**Consultation Response from KC,
Trees****2024/90769 adj, 27, Riley Park, Kirkburton, Huddersfield, HD8 0SA****Erection of one detached dwelling and associated works****Date Responded: 30/04/2024****Responding Officer: D. Atkinson****Responding Ref: CA15**

Section FF
Scale: 1 : 20

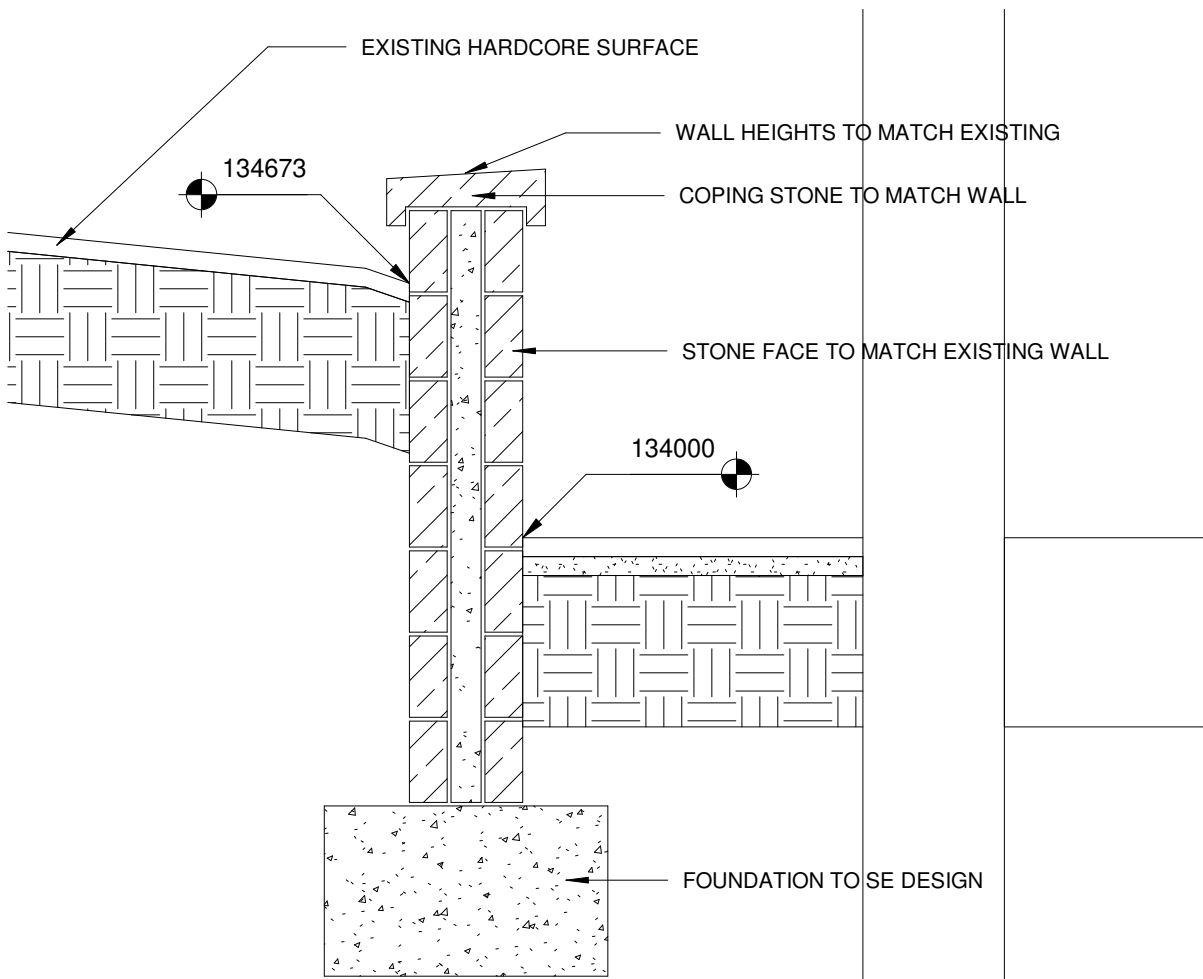
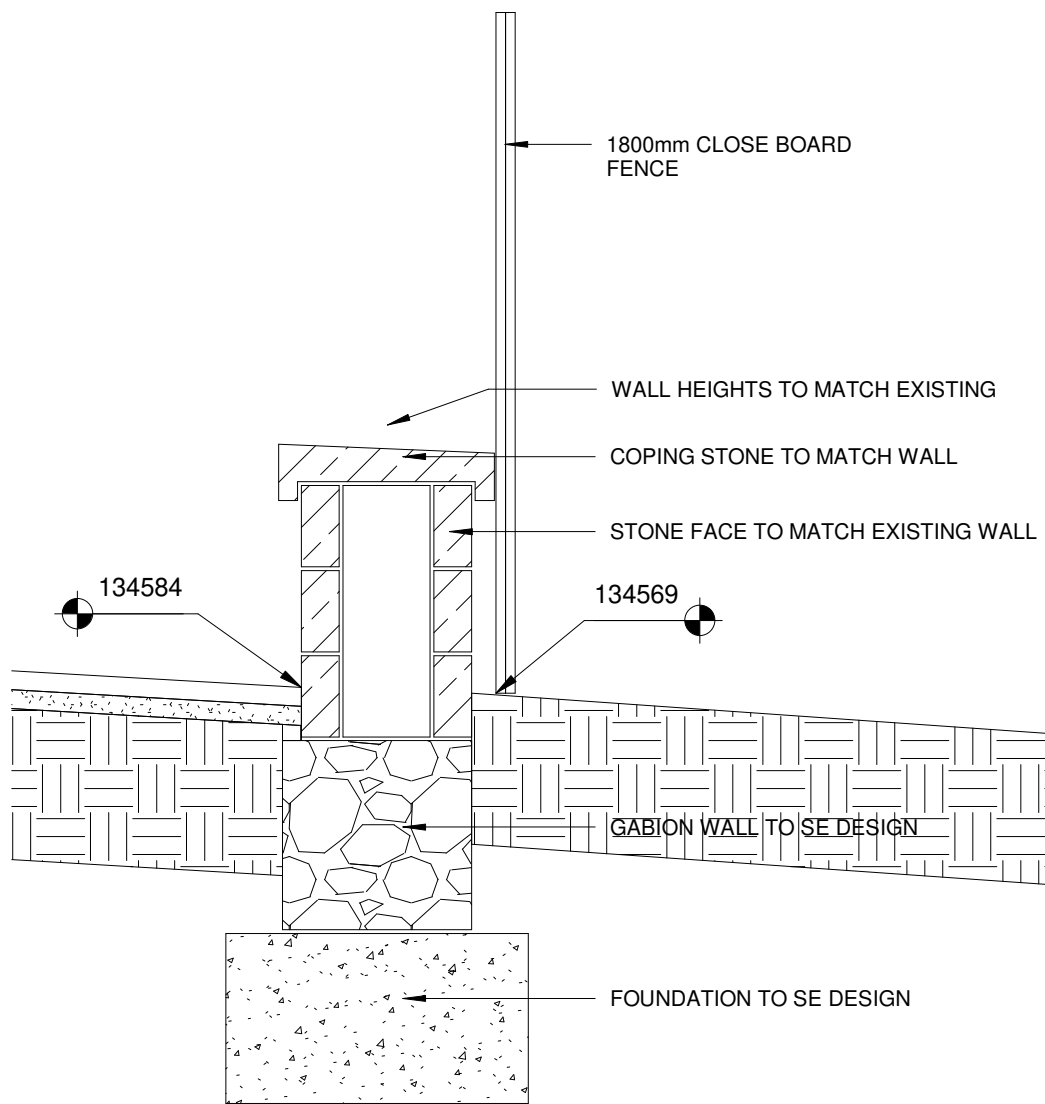
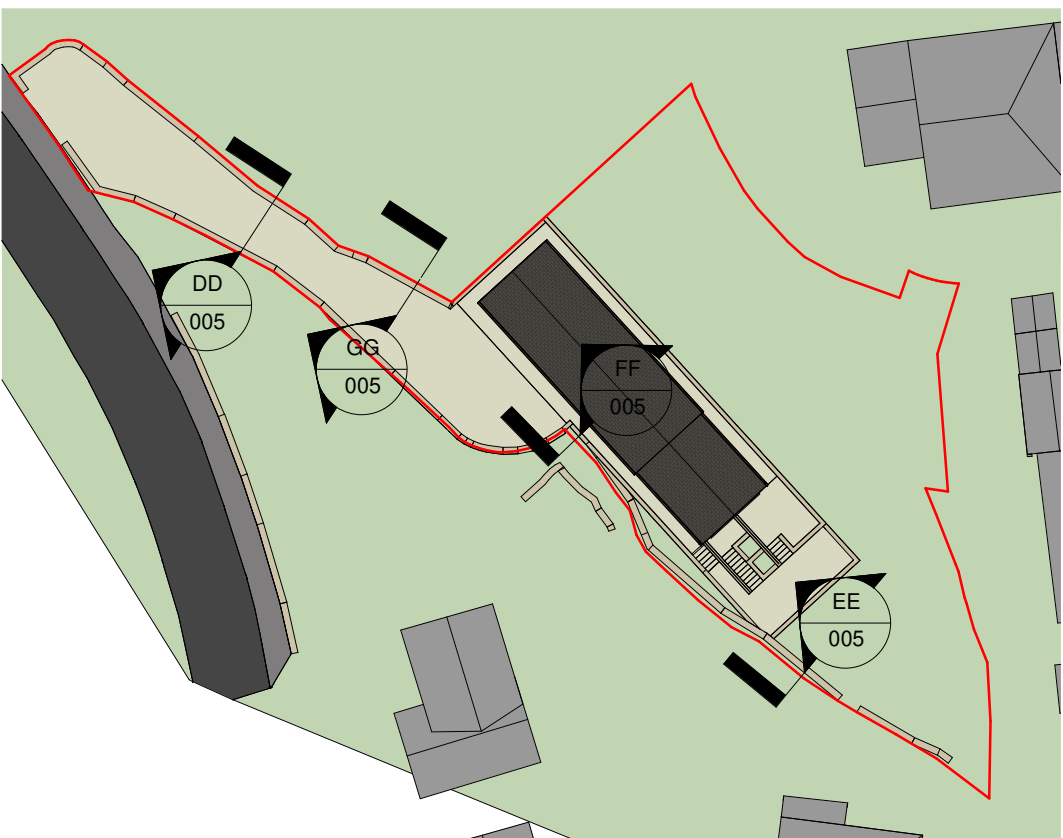
From drawing 3106-005, the construction appears to significantly encroach into the RPA of the Cedar (T3).

Title TREE CONSTRAINTS PLAN

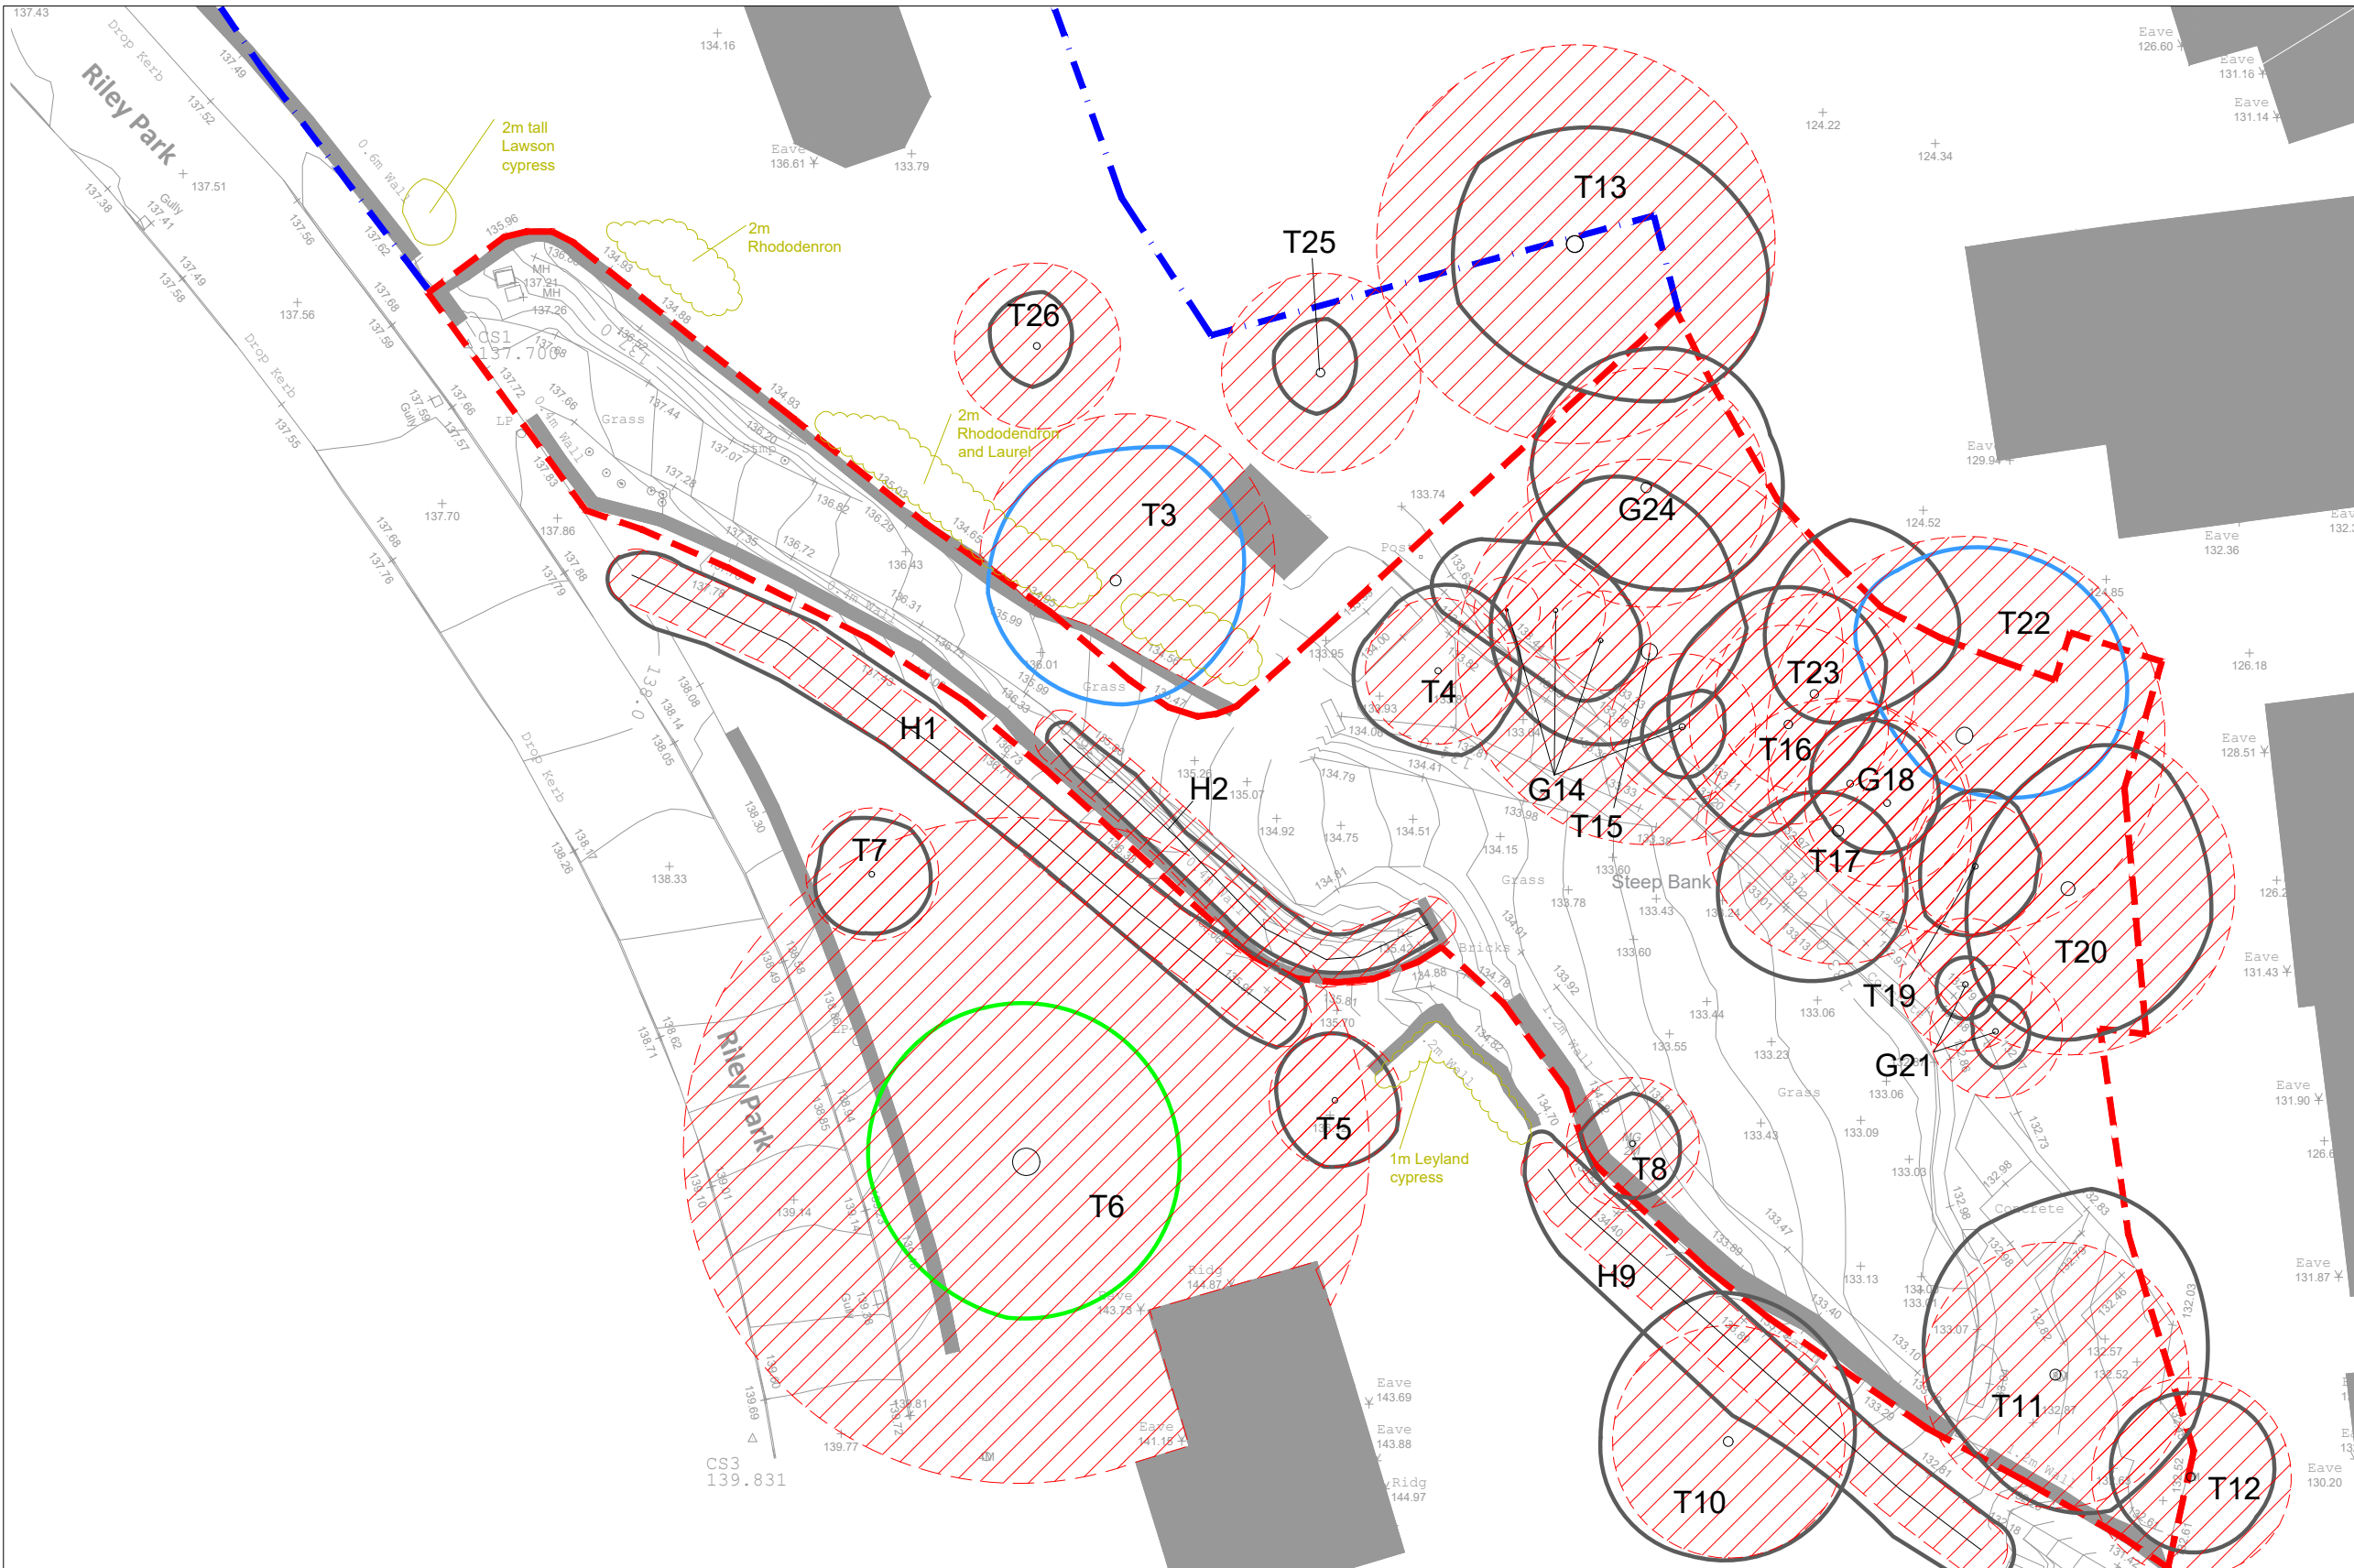
From the information provided the proposed is nestled amongst existing trees and requires the pruning and remove of a couple of trees in order to facilitate. These are H2, T4 and T8 that require removal and T15 and T17 that require facilitation pruning.

The 20% reduction of T15 is the most significant works proposed in terms of trees.

This puts T15 – T24 and T11 at risk of pruning or removal, in KC Trees opinion.

The property and the small amount of usable garden space there is also right next to H9, which is a 3m tall cherry laurel hedge.
